**Re: Opus Transport Apartment**  
**2900 Transport St. SE**  
**Traffic Circulation Layout**  
Engineer's Stamp 08-16-24 (M15-D023H)

**RE: 2023065 TRANSPORT APARTMENTS – OPUS  
2900 TRANSPORT ST. SE  
TRAFFIC CIRCULATION LAYOUT**

Per the correspondence February 6, 2024, please find the following responses addressing the comments listed below:

Figure 4: Proposed Striping and Intersection Mitigation

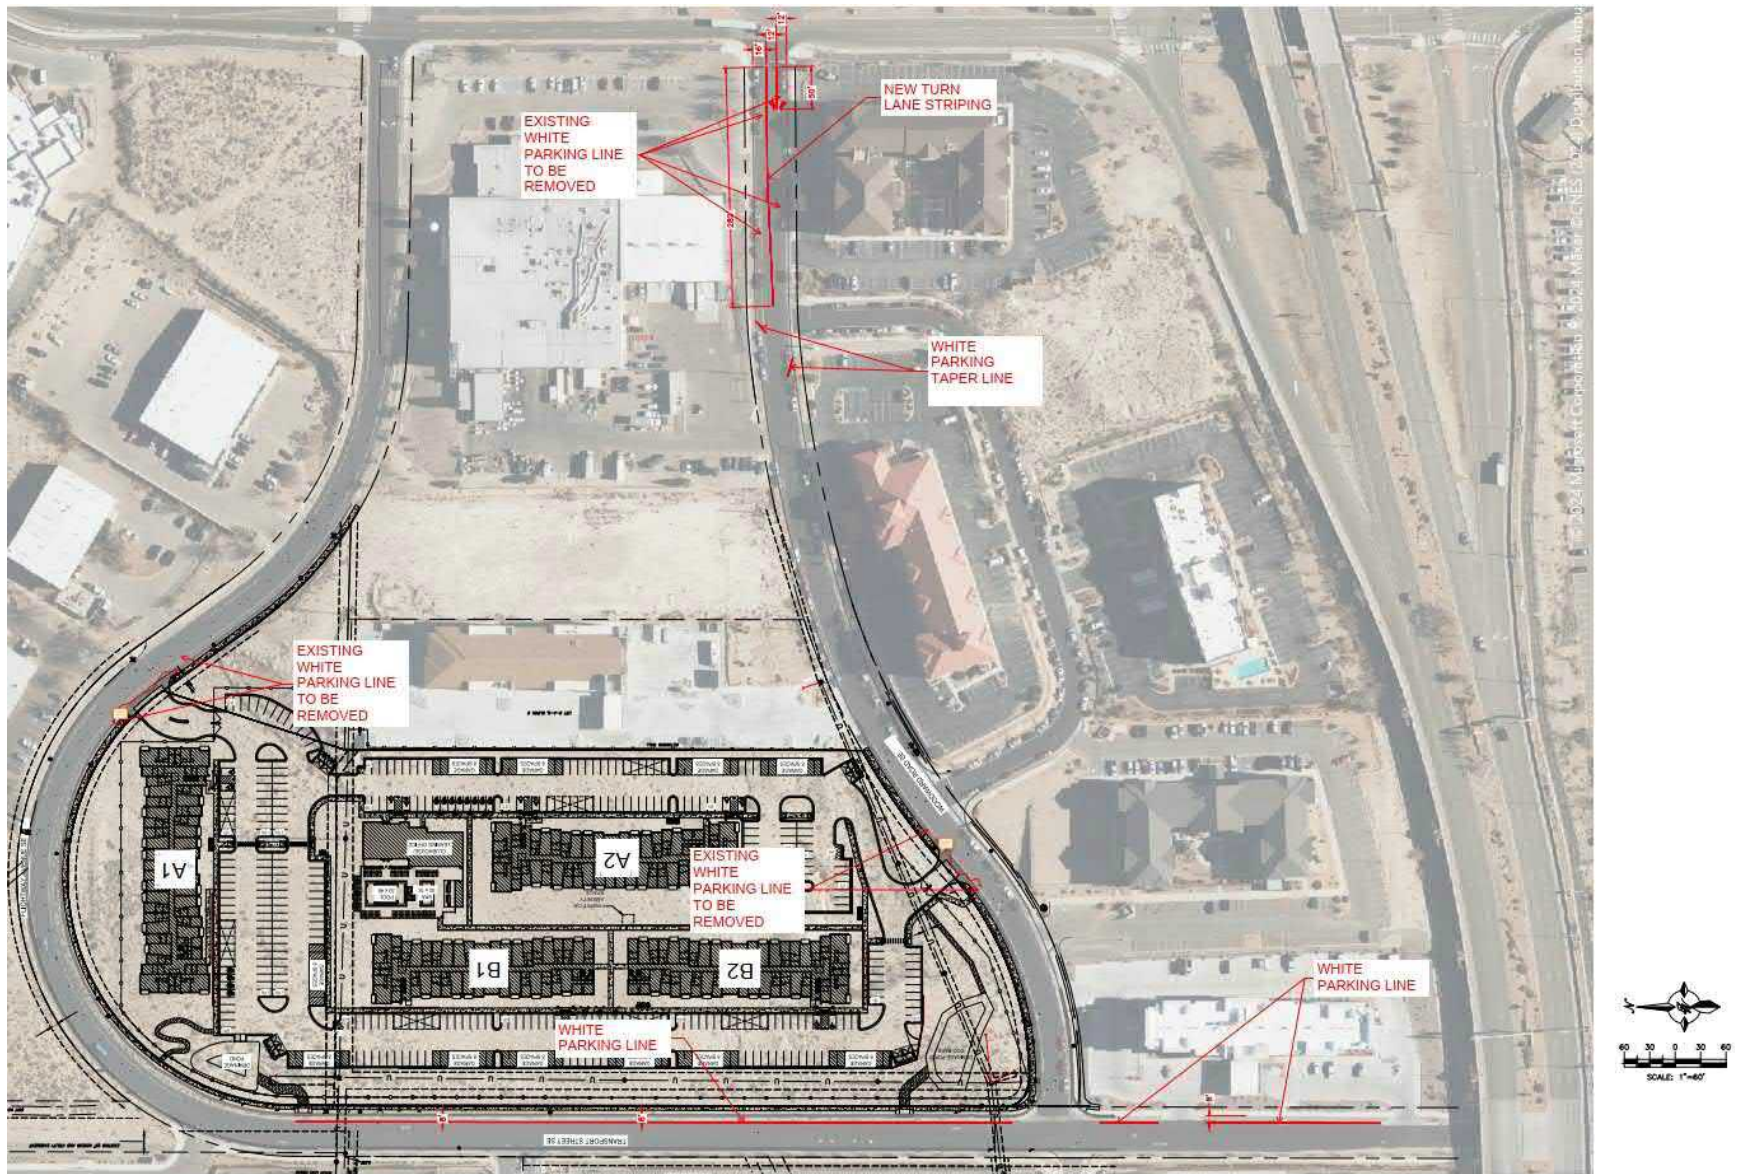
Required infrastructure improvements per the Study include pavement markings as shown on Figure 4, p. XV.
